February 8, 2013

**RE: Old Barn Estates - Proposed Residential Subdivision
1062 Ocean Avenue & Ledgewood Drive
Final Subdivision Review Submission**

We have prepared the following narrative in response to questions raised at the January workshop, by City Planning Staff, and per the requirements of the City of Portland's Subdivision Final Review. The narrative includes comments and responses previously submitted to the City to provide a history to the various design/project concepts and decisions.

PLAN 1 OF 2

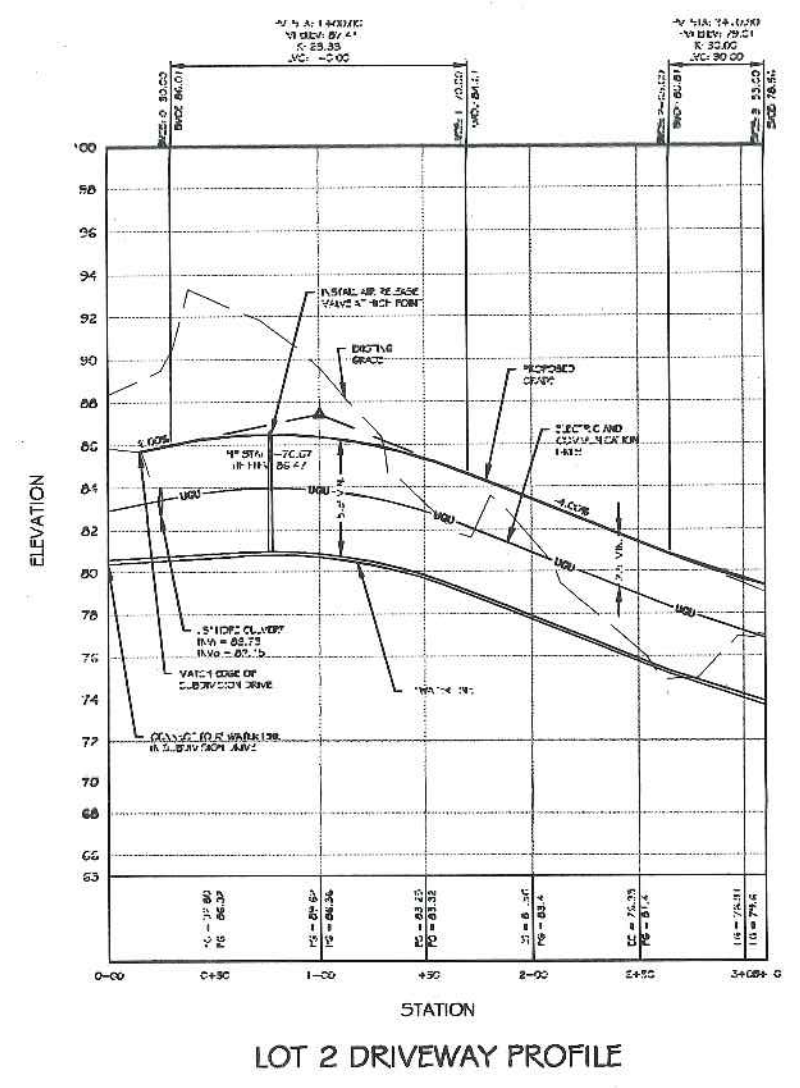
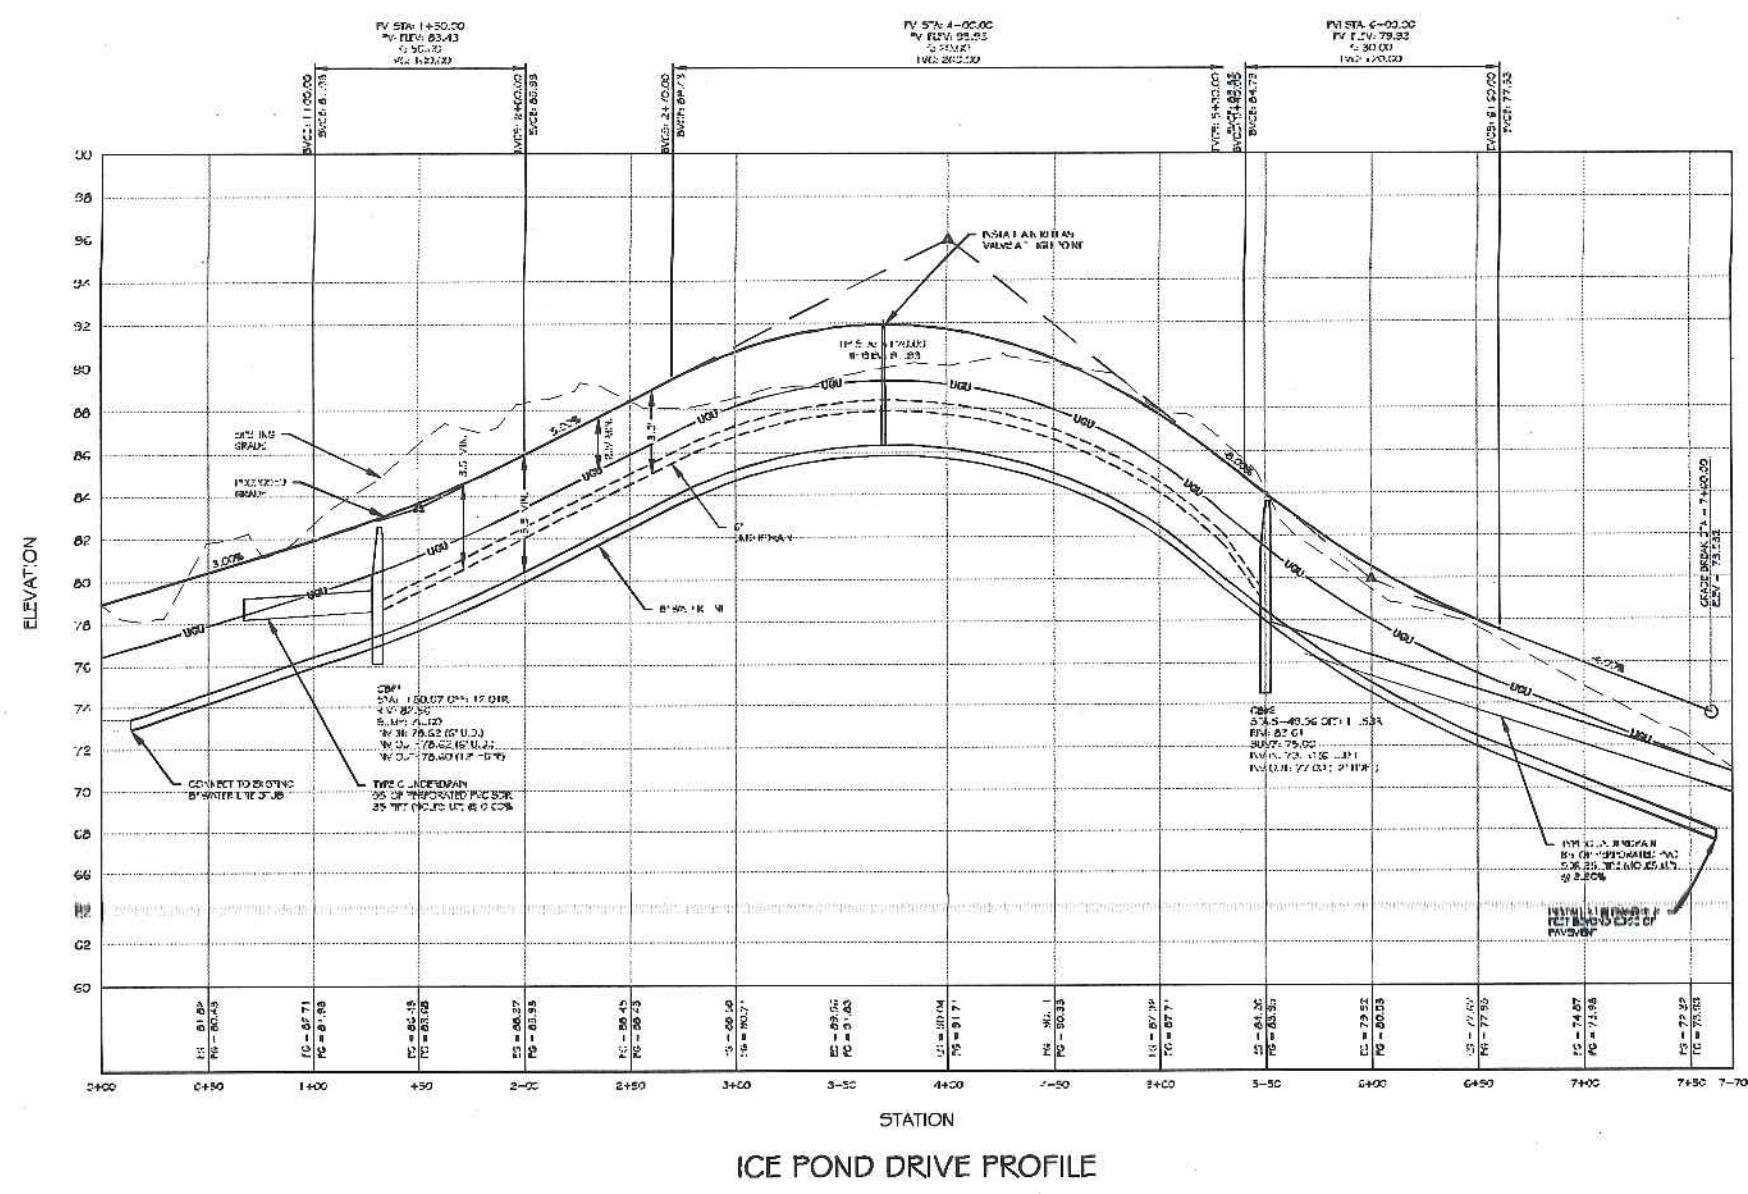
- *Requested delineation of the AE Flood Zone: **The delineation has been submitted as part of a previous submission. Only a small corner, located within the stormwater easement, of lot 9 is within the 100 year flood zone (see plan S-101.***
- *Ice Pond Drive is not meeting the requirements of 14-403 which requires streets to be put in from wherever pavement ends to the end of the lots being developed. **We have worked with City Staff to reconfigured lots 8 and 9 so that they no longer have frontage along a R.O.W that does not include a paved street. The R.O.W. has been pulled back to 3' off the edge of where the street pavement ended and the land divided equally between lots 8 and 9.***
